Costin Roe Consulting Pty Ltd

**Re: Ardex Facility, SSD-25725029  
Response to Additional Request for Information  
Flooding and Flood Response**

We provide this letter in relation to the Request for Information (refer **Enclosure 1**, DPIE letter dated 31 August 2022) from NSW DPIE regarding the development of a facility for Ardex currently being assessed as SSD-25725029. This letter specifically discusses Item 5 of the RFI which states:

**BULK EARTHWORKS CUT/FILL PLAN**  
SCALE 1:500

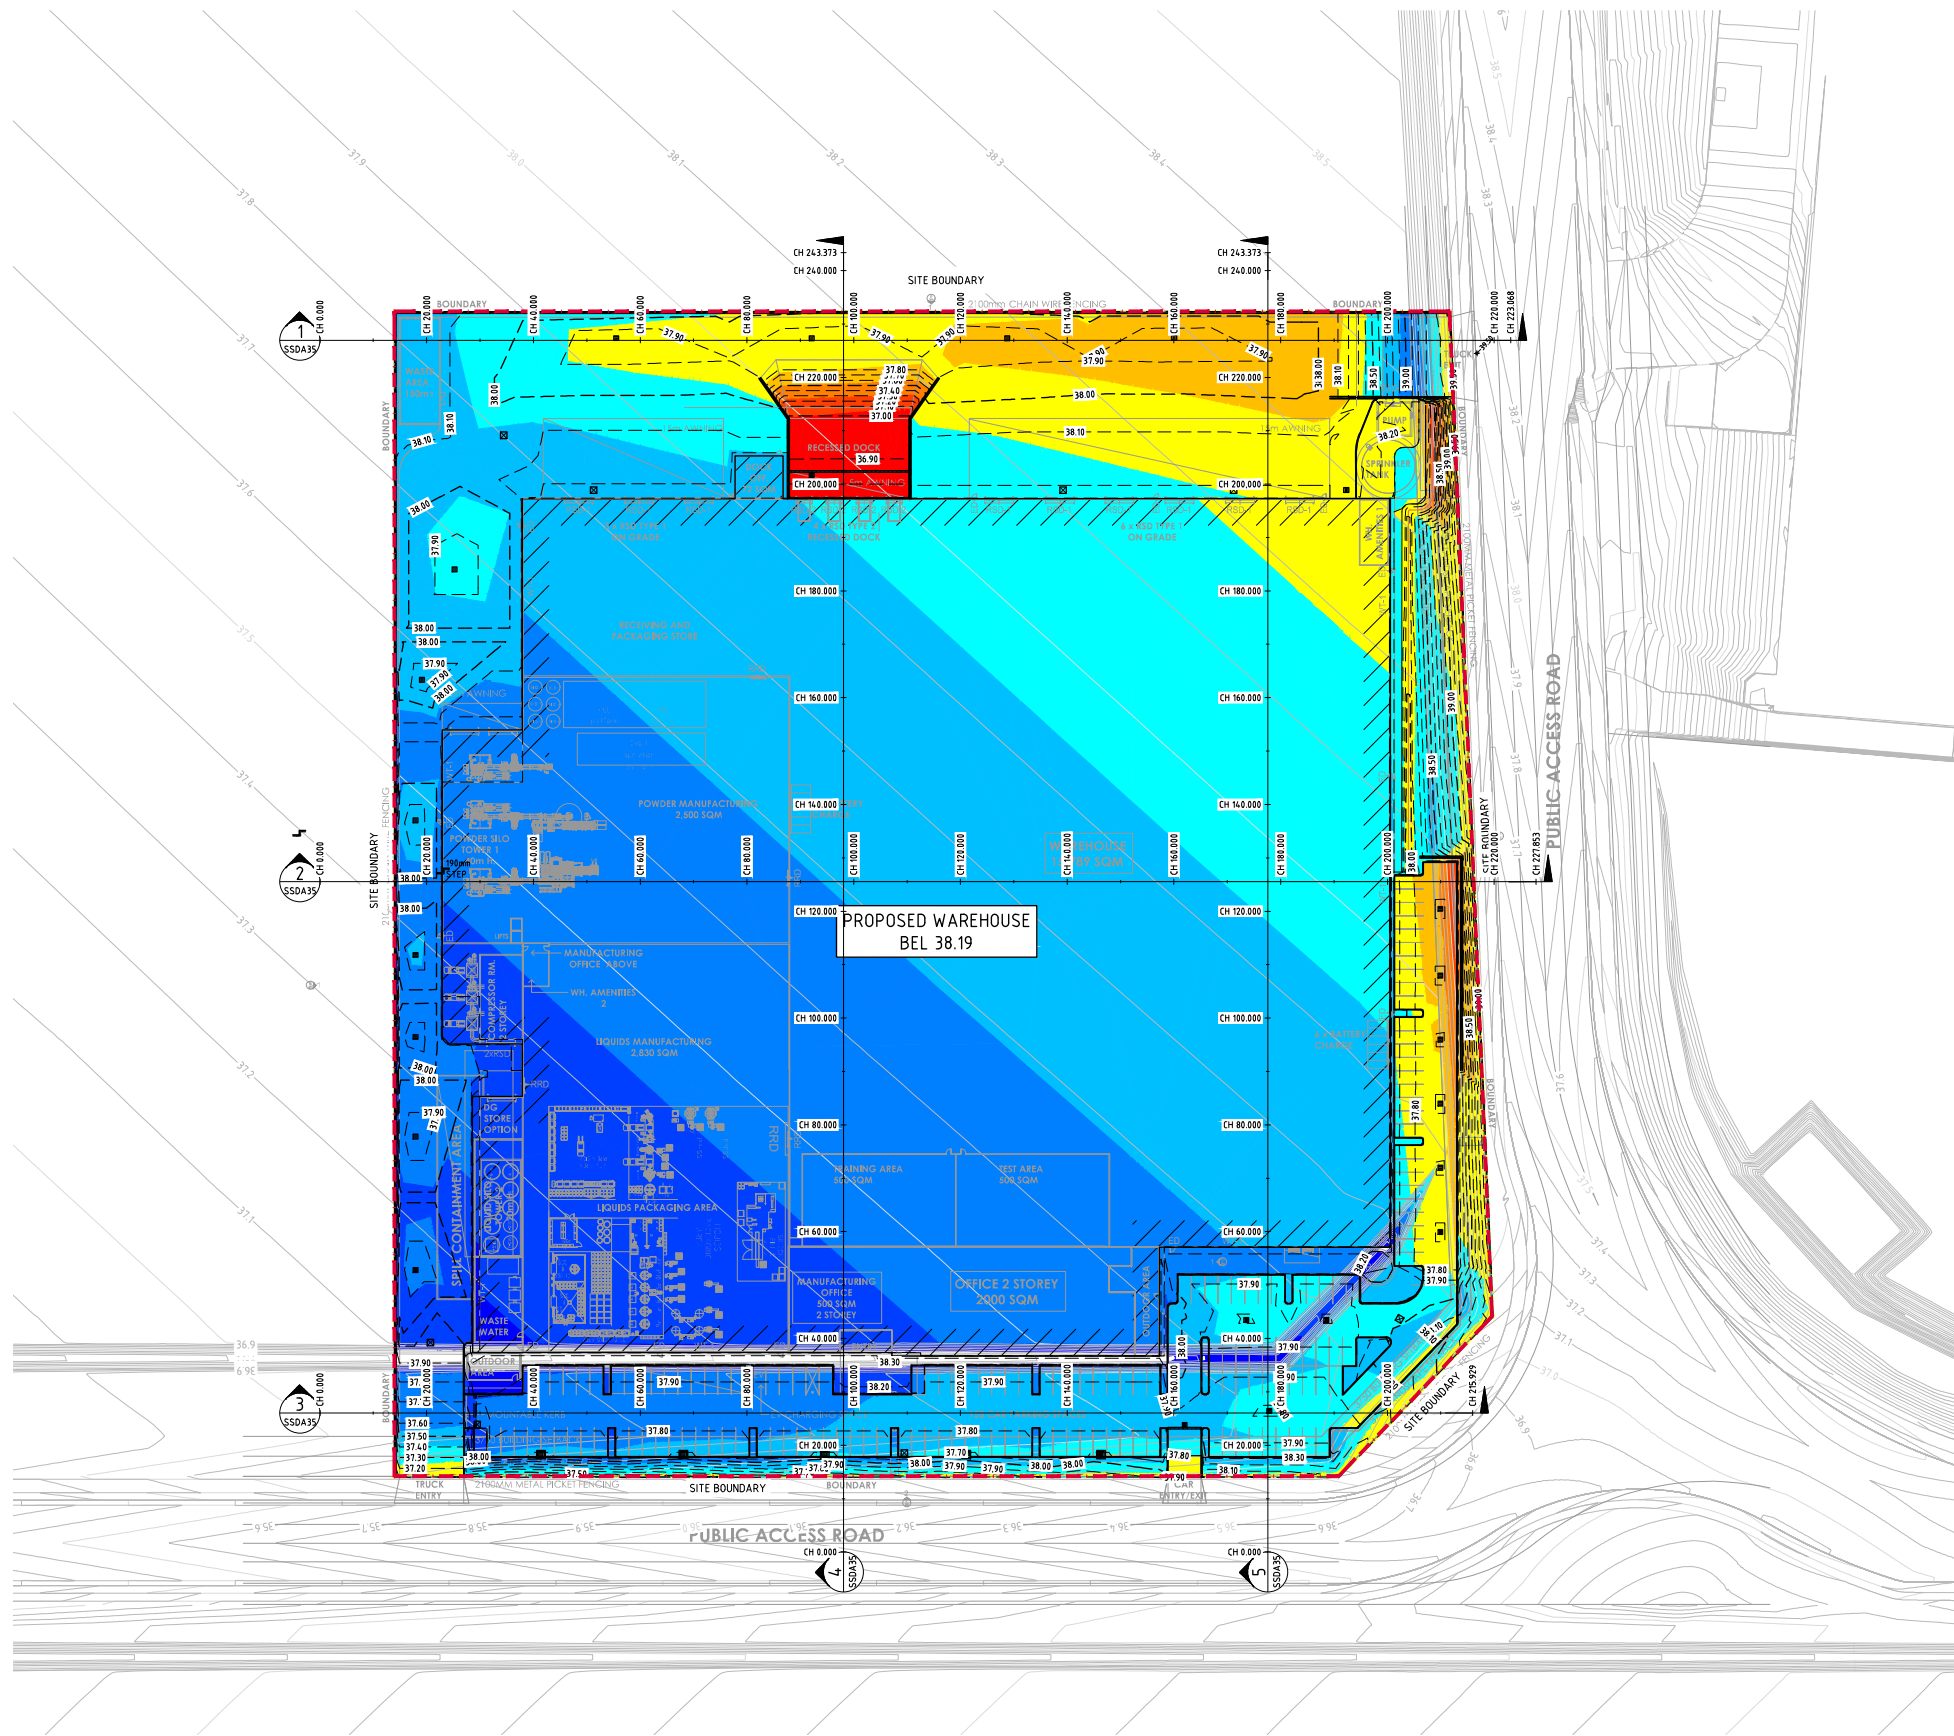
*5. The Civil Engineering Report (Appendix C3 of the RtS) states that potential flooding impacts as a result of post-development flows were assessed under SSD-9522. The Department notes that the details of the proposed cut, fill and construction works did not form a part of the flood assessment completed under SSD-9522. Please explain how flooding impacts of the proposed development were adequately addressed under SSD-9522 or provide an addendum to the Civil Engineering Report to address this issue.*

Sketches **Co13362.05-SK01** to **SK03** are included in **Enclosure 2**. These sketches show the Ardex Facility overlain over the approved 1% AEP pre and post development flood extent drawings, and the PMF post development flood extent drawings respectively. The pre and post development 1% AEP flood level is RL 34.4m AHD and the PMF is RL 36.4m.

Noting the proposed floor level of the building is RL 38.5m AHD, and the approved SSD-9522 filling level varied between RL 37.2m and RL 38.4m AHD, both the approved SSD-9522 filling levels and proposed SSD-

25725029 building are clear of both the 1% AEP and PMF levels. The construction of the proposed Ardex Facility as such will not change any outcomes achieved in the approved SSD-9522 flood impact assessment.

It is noted that the built form development footprint presented in this report is clear of and does not impact the 1% AEP event and that all development lots are above the PMF flood water levels. It is further noted that there are no changes to the flood impacts or outcomes of the approved modelling associated with this Application.
